PLANNING CONSULTATION RESPONSE

Application No	<u>2026/0619</u>
Proposal	Retrospective change of use of the former Lundwood Social Club (Sui Generis) to an MOT and tyre service unit (Sui Generis) including installation of roller shutter; and proposed change of use Lundwood Social Club (Sui Generis) to Class E(a) retail unit with associated works.
Address	Lundwood Social Club, Pontefract Road, Lundwood, Barnsley, S71 5PN
Date of Consultation Reply	07/09/26
Consultee	Highways Development Control

Project: Lundwood Social Club, Pontefract Road, Lundwood, Barnsley, S71 5PN		
Drawing Title: Proposed Floor Plans		
Drawn: DK	Date: May 26	Scale: 1:100@A1
Project No. 1666	Drawing No. 1666-03	Revision: 03

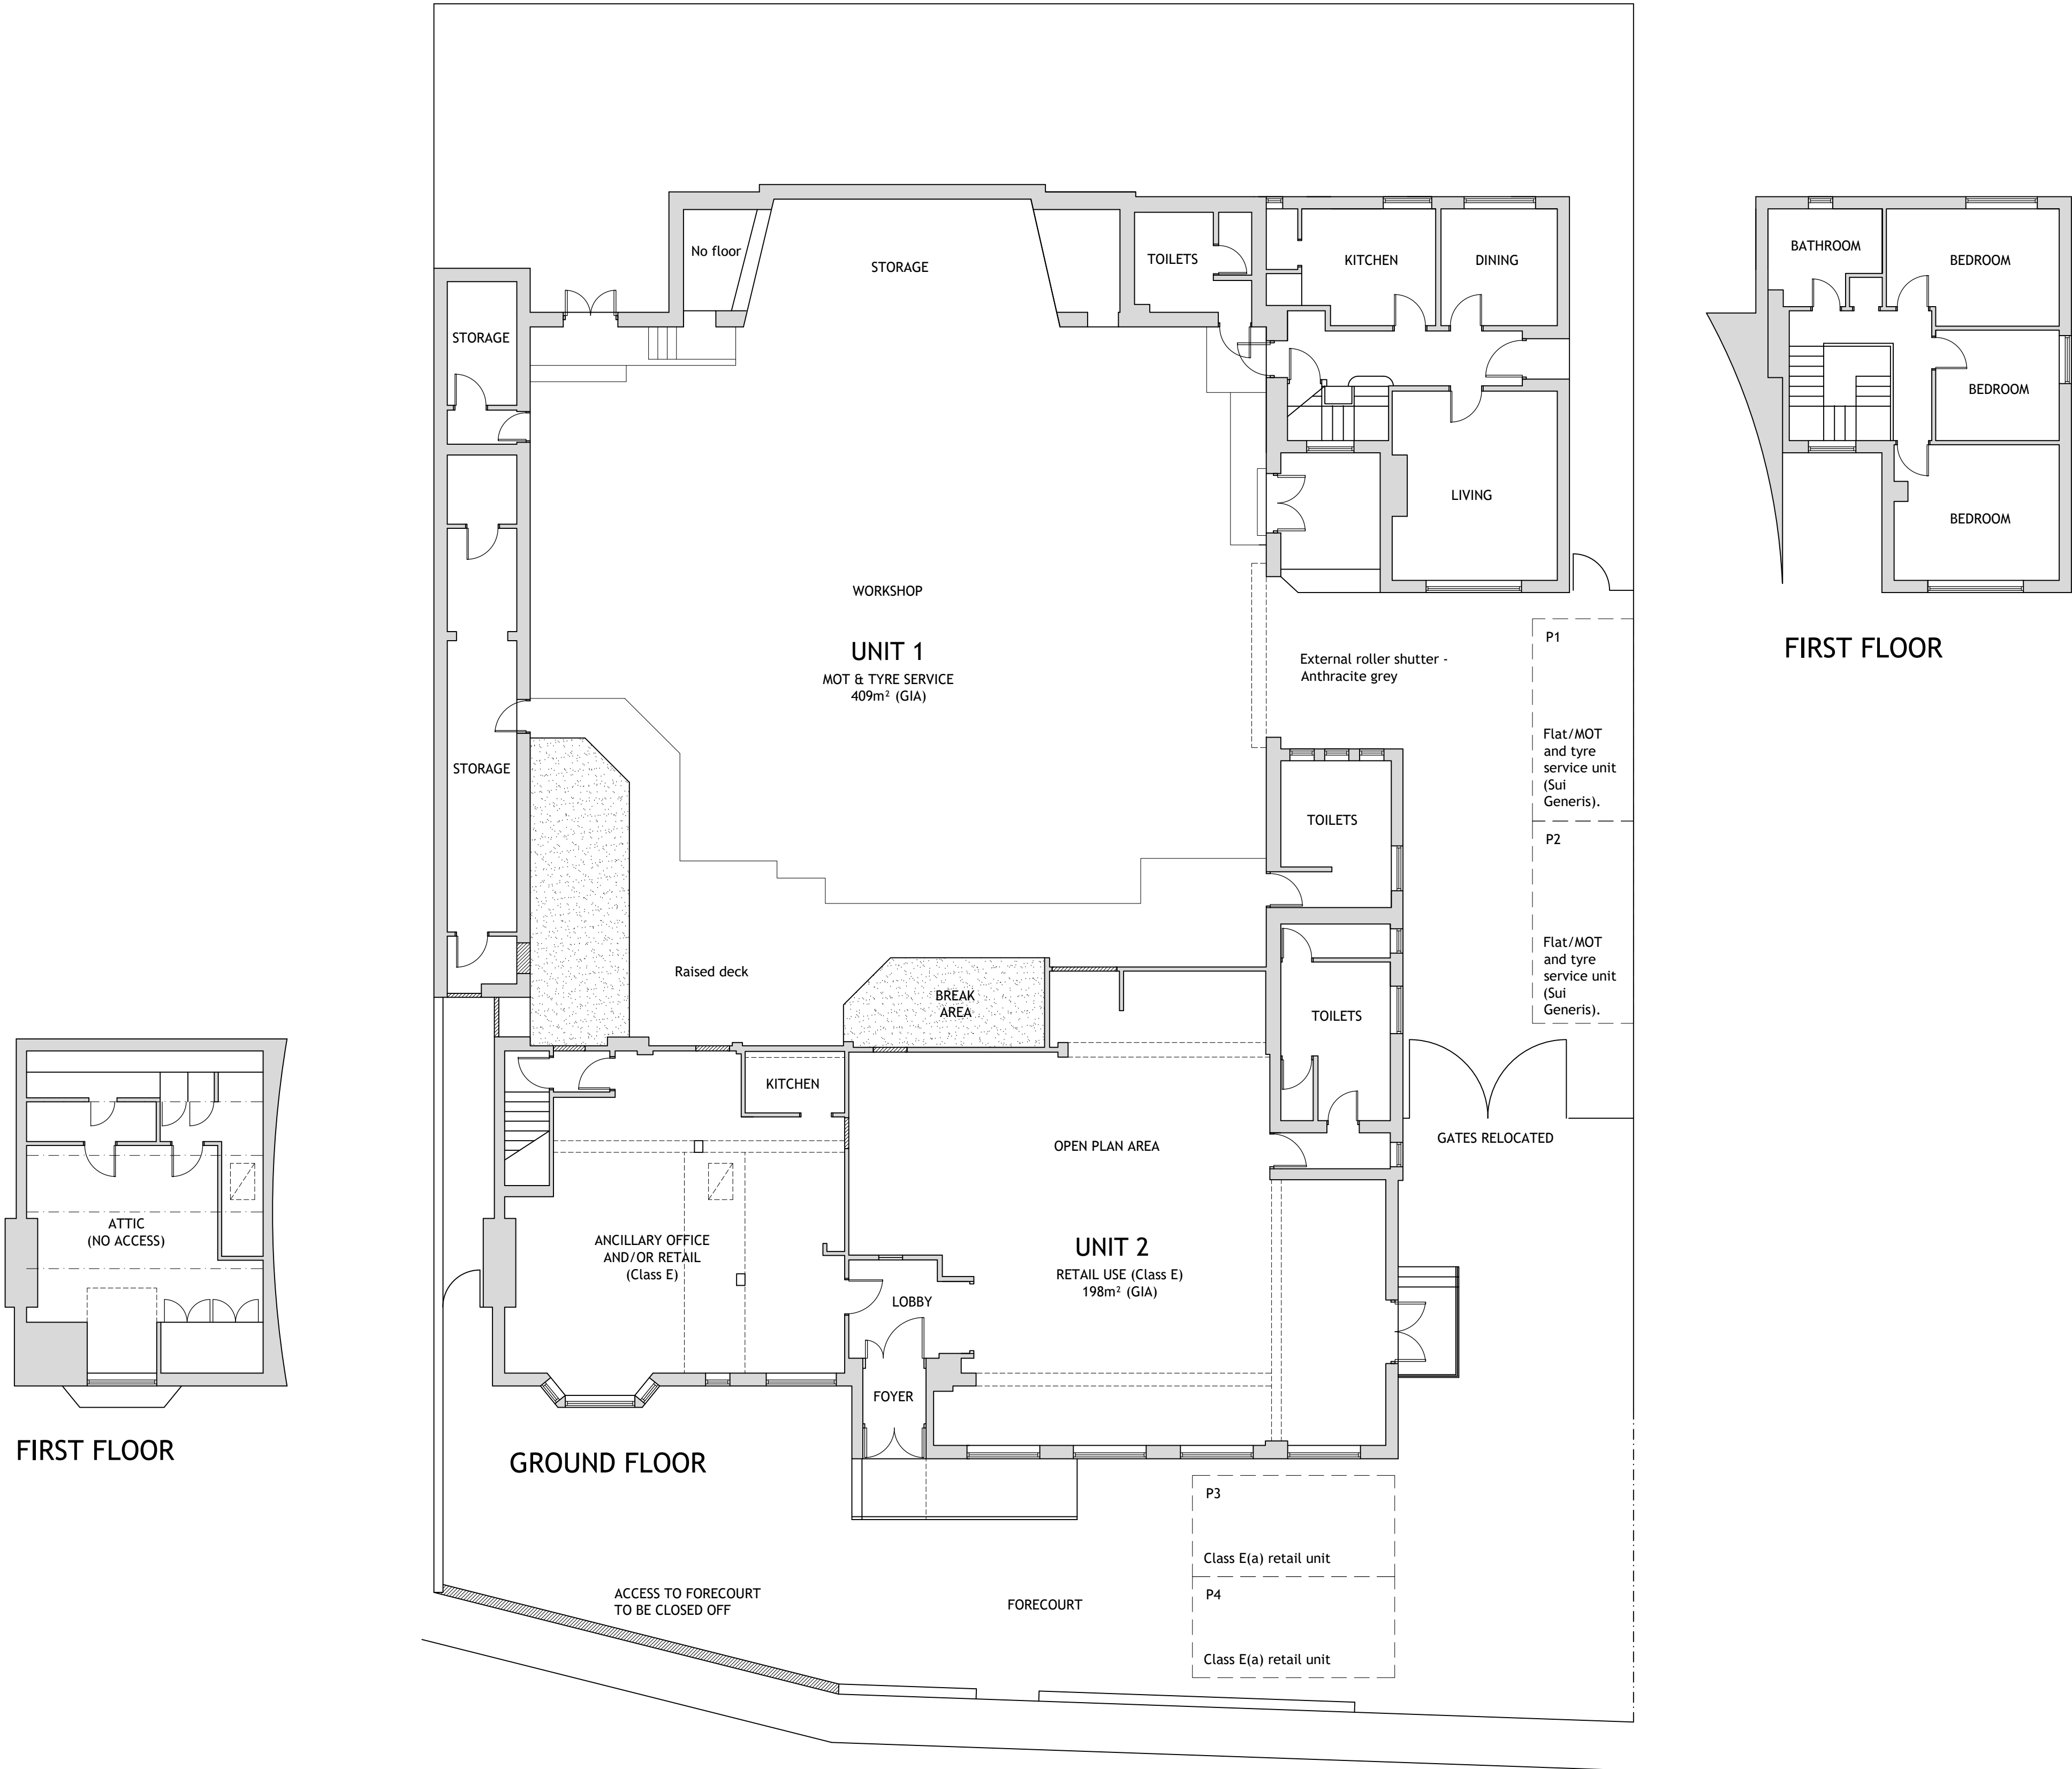
In relation to the proposed retail use, two customer parking spaces are shown within the front forecourt. The submitted swept-path analysis however, does not satisfactorily demonstrate that these spaces can operate independently of the adjoining MOT and tyre business.

The tracking provided appears to rely upon vehicles manoeuvring through or within the area beyond the gated entrance serving the MOT and tyre unit in order to access the parking spaces and leave the site in a forward gear. Should these gates be closed, it is clear that there is insufficient space for vehicles to access the parking spaces.

I also note that the Technical Note advises that servicing and deliveries associated with the retail and MOT/tyre uses would take place outside normal operating periods so that sufficient space is available within the forecourt. However, no swept-path analysis has been provided for a servicing or delivery vehicle. Tracking should therefore be submitted for the largest vehicle anticipated to service the proposed retail premises, demonstrating that it can satisfactorily enter, manoeuvre within and leave the site without reversing onto Pontefract Road.
